# National Construction Code (BCA) 2013 Assessment Report

## ***AXIS (STAGE 1A)*** ***2/4 AUSTRALIA AVENUE, SYDNEY OLYMPIC PARK,*** ***NSW***

**Construction of a mixed commercial and retail development over a  
two- level basement car park**

Date: *10 May 2013*

Figure 8: Stage 1A – Typical Floor Level

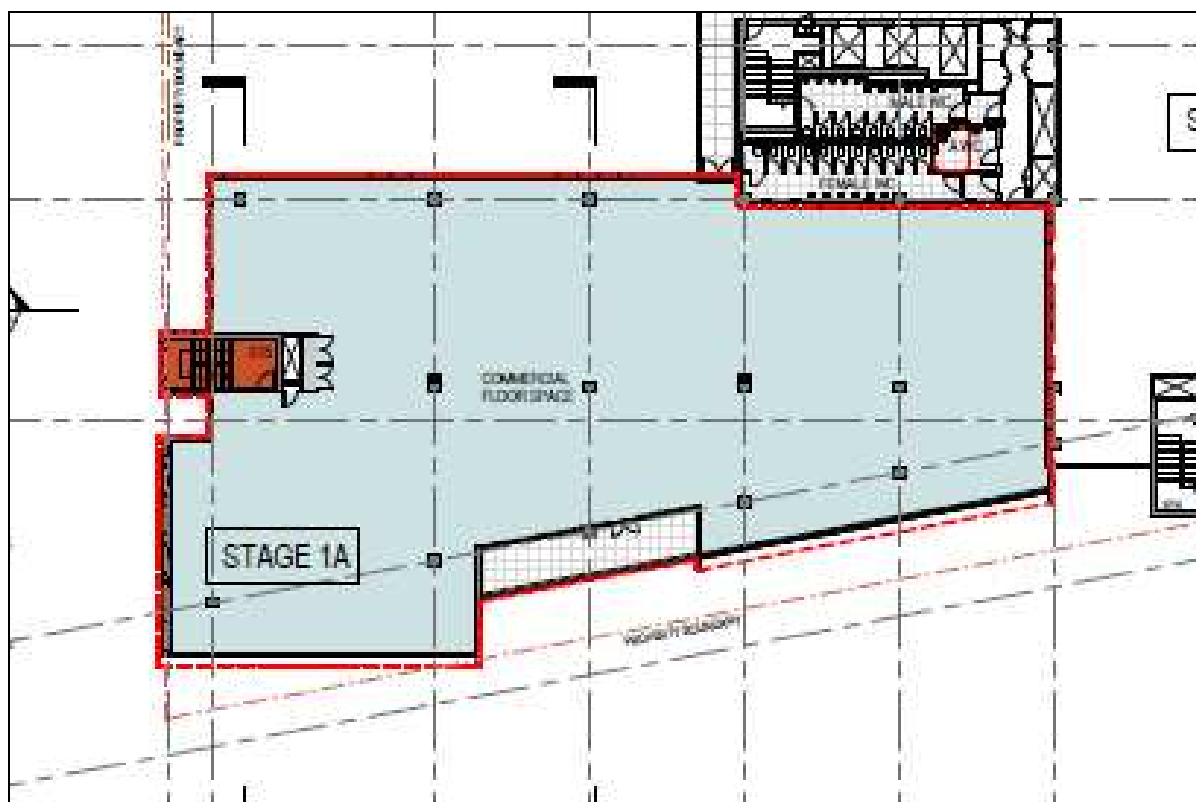
- a) The distance between Fire Stair 5 (Stage 1a) and Fire Stair 4 (Stage 1) measures approximately 54m (in a straight line). However it is acknowledged that the FEBQ has already acknowledged distances between exits allowing up to 90m.

- a) Fire stair 5 at the commercial levels, where there is the potential to divide the floors into separate tenancies.

On this basis, there is a non-compliance relating to clause D1.7 (a)(ii) where the sole occupancy unit may not occupy the whole storey and an airlock or similar may be required.

To be addressed further in the Fire Engineering Report pursuant of the Construction Certificate stage.

It is understood that a C10 Accredited Fire Engineer is preparing an Alternative Solution to address the confirmed deemed-to-satisfy non-compliances of Performance Requirement DP4, as stated in the FEBQ for Stage 1 and 1A pursuant of the Construction Certificate stage.
